East Pye Solar
Applicant's Response to Advice and Observations at
Acceptance

Planning Inspectorate Reference: EN0110014

Document Reference: APP/8.1

Planning Act 2008: Application for a Development Consent Order for East Pye Solar - Response to Section 51 Advice

- ▭ Visibility of Existing
- ▭ Increased Visibility due to Proposed

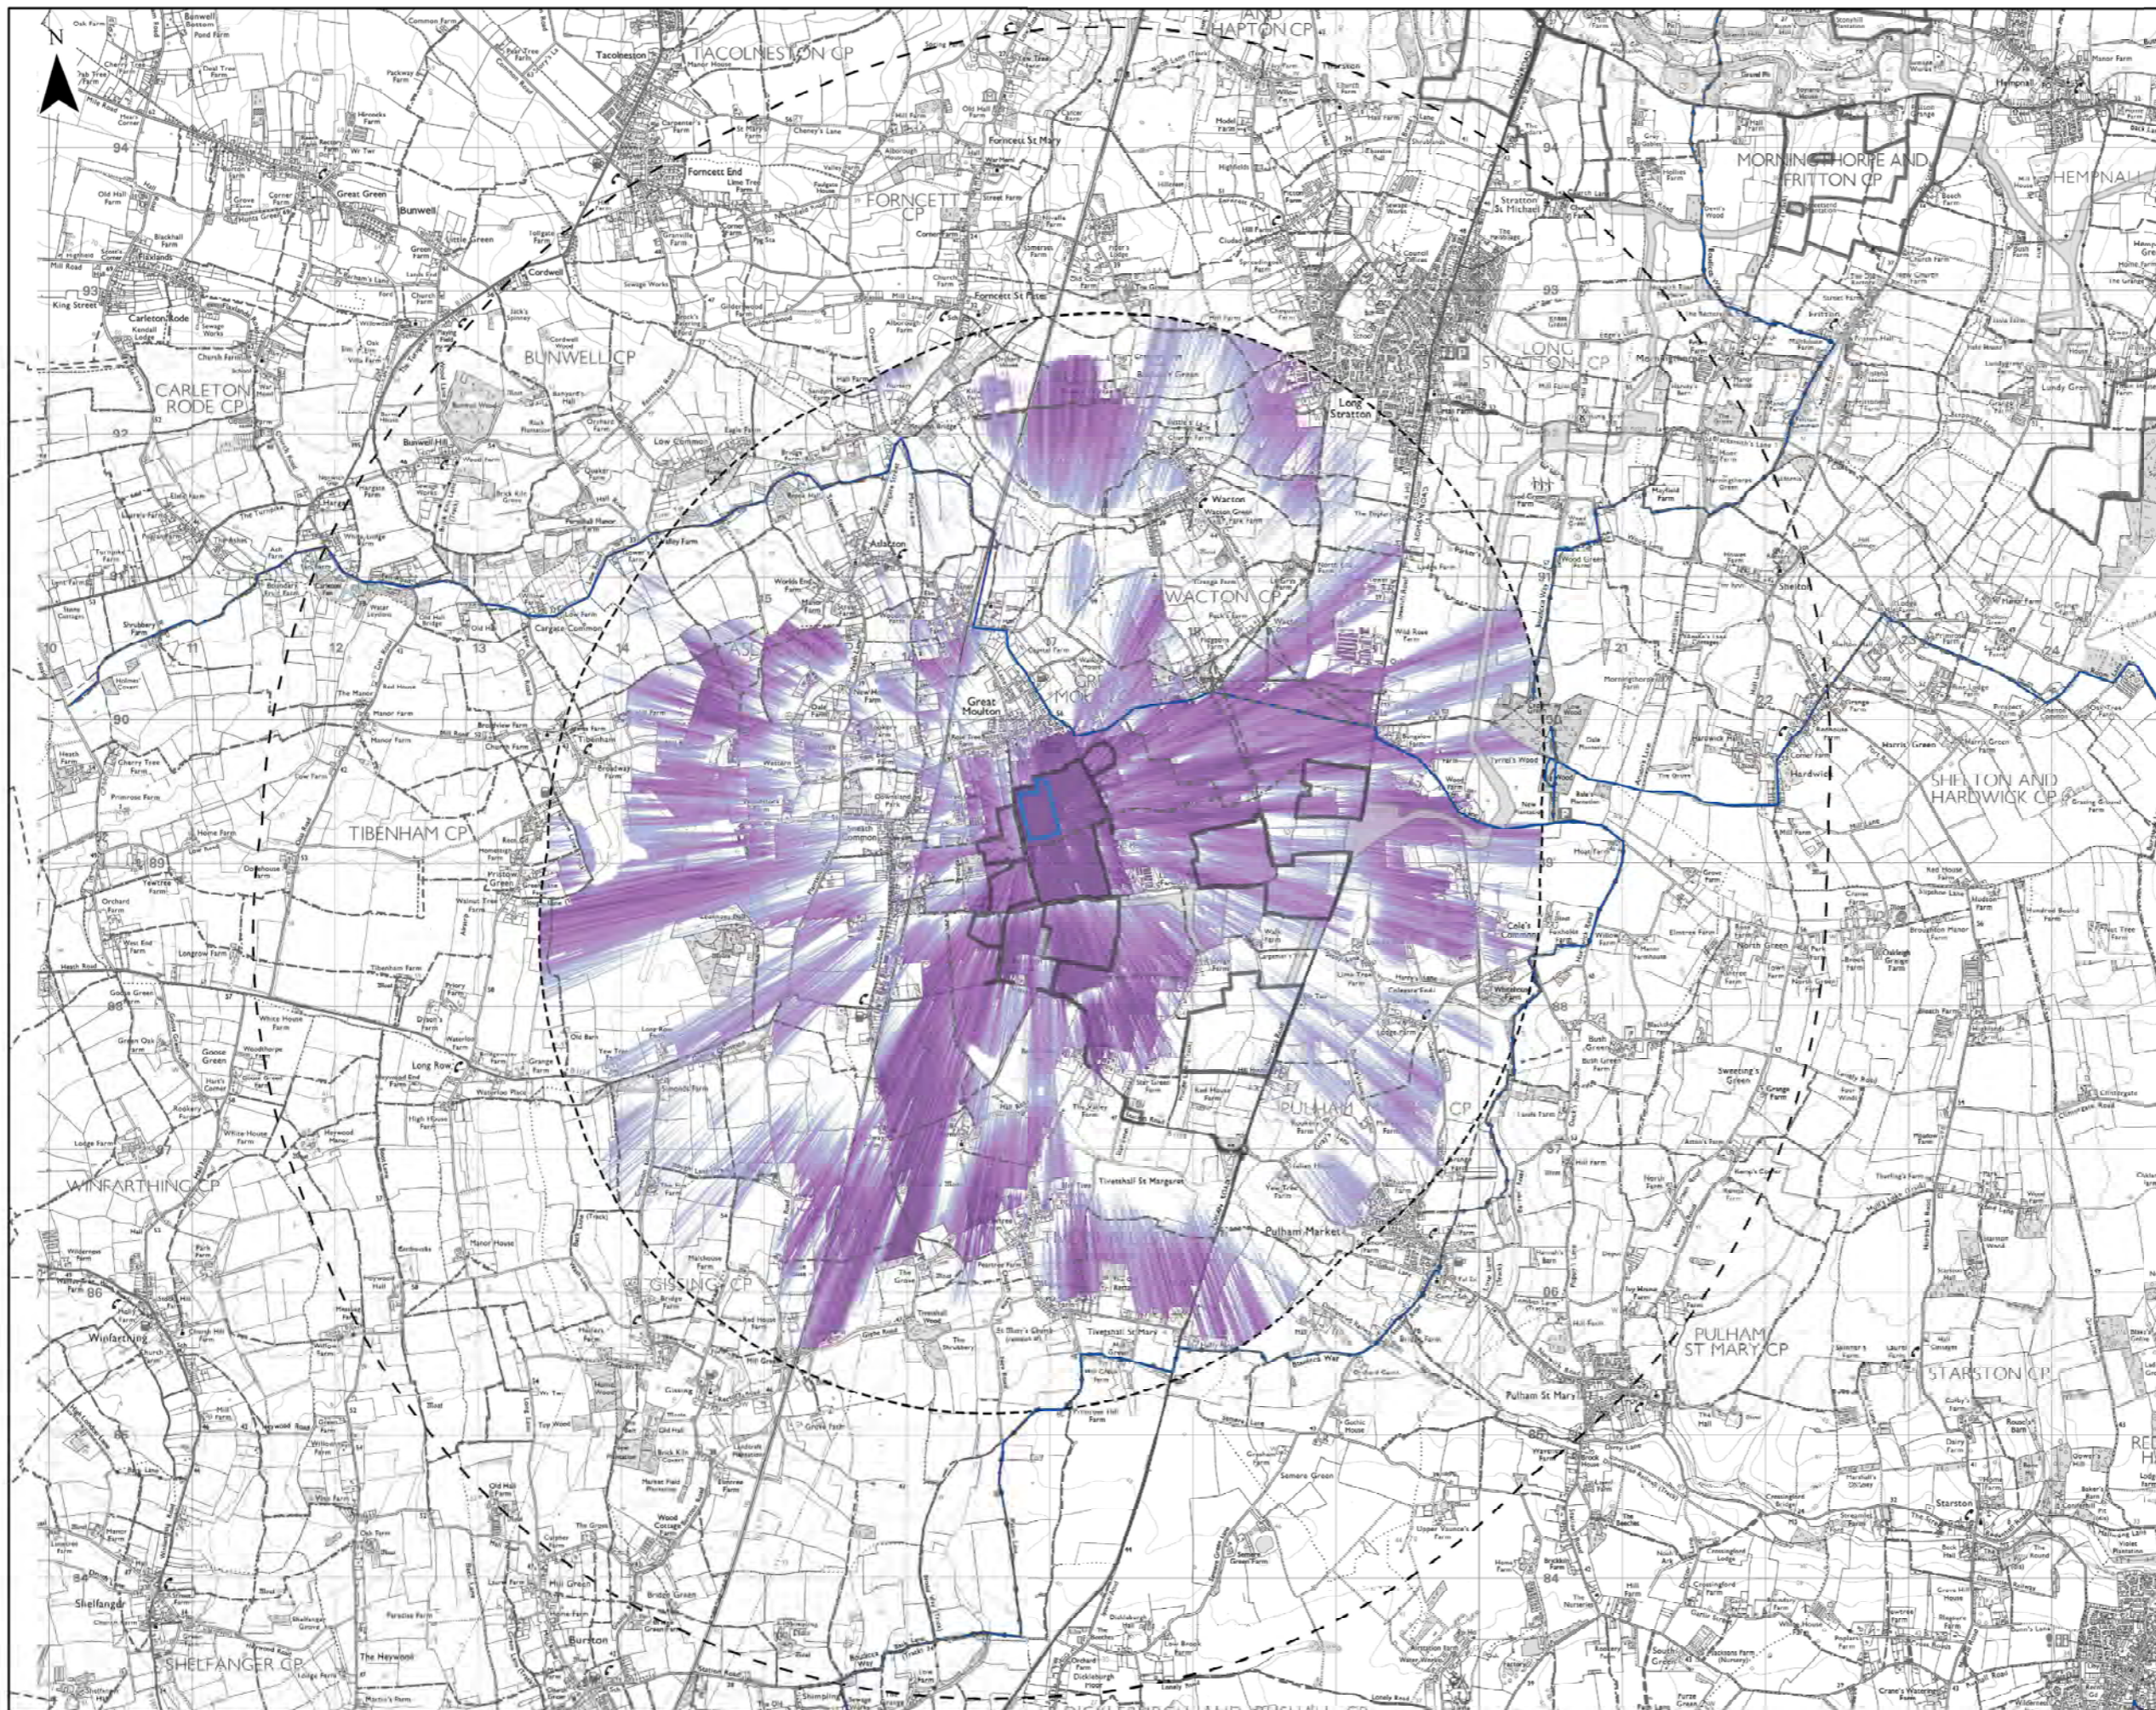
Plans and Figures The applicant is asked to submit revised Volume 2 and 6 documents that eliminate rendering issues and allow multiple files to be opened concurrently. This applies to several figures (such as documents 6.2.5.4, 6.2.7.5 (10), 6.2.7.6, 6.2.7.7, and 6.2.15.1), which range in size from 42.5 MB to 90.8 MB, plan document numbers 2.3 (69 MB) and 2.12 (78.1 MB), as well as to appendices attached to Environmental Statement chapters, such as document 06.03.18.01, which is 145.9 MB.	Reduced file size versions of the following DCO Application documents were provided to the Planning Inspectorate with the Applicant's initial response to the Section 51 advice [AS-001]. Where reducing the size of documents was not feasible, the document has been split into Parts. ■ Works Plan. Part 1 and Part 2 [AS-002 and AS-003]. ■ Hedgerow and Tree Protection Order Plan [AS-004].

Planning Inspectorate Comments	Applicant's Response
	■ Environmental Statement Volume 2: Figure 5.4 – Alterations to the Site Boundary between the PEIR and Submission [AS-006]. ■ Environmental Statement Volume 2: Figure 7.5.10 – Site 1 Zone of Theoretical Visibility [AS-007]. ■ Environmental Statement Volume 2: Figure 7.6 – Visual Receptors Plan [AS-008]. ■ Environmental Statement Volume 2: Figure 7.7 – View Locations and Visualisations [AS-009]. ■ Environmental Statement Volume 2: Figure 15.1 - ALC Results [AS-010]. ■ Environmental Statement Volume 3 Appendix 7.5 Photosheets – Cable Route Corridor. Part 1 and Part 2 [AS-011 and AS-012]. ■ Environmental Statement Volume 3 Appendix 7.5 Photosheets – Site 7. Part 1 and Part 2 [AS-013 and AS-014]. ■ Environmental Statement Volume 3 Appendix 7.6 Figure 7.6.7 Visualisations – Site 7. Part 1 and Part 2 [AS-015 and AS-016]. ■ Environmental Statement Volume 3: Appendix 8.1– Ecological Desk Study and Extended Habitat Survey [AS-017]. ■ Environmental Statement Volume 3: Appendix 9.1– Flood Risk Assessment & Outline Surface Water Drainage Strategy [AS-018 and AS-019]. ■ Environmental Statement Volume 3: Appendix 10.2 – Archaeological Desk-Based Assessment. Part 1 and Part 2 [AS-020 and AS-021].
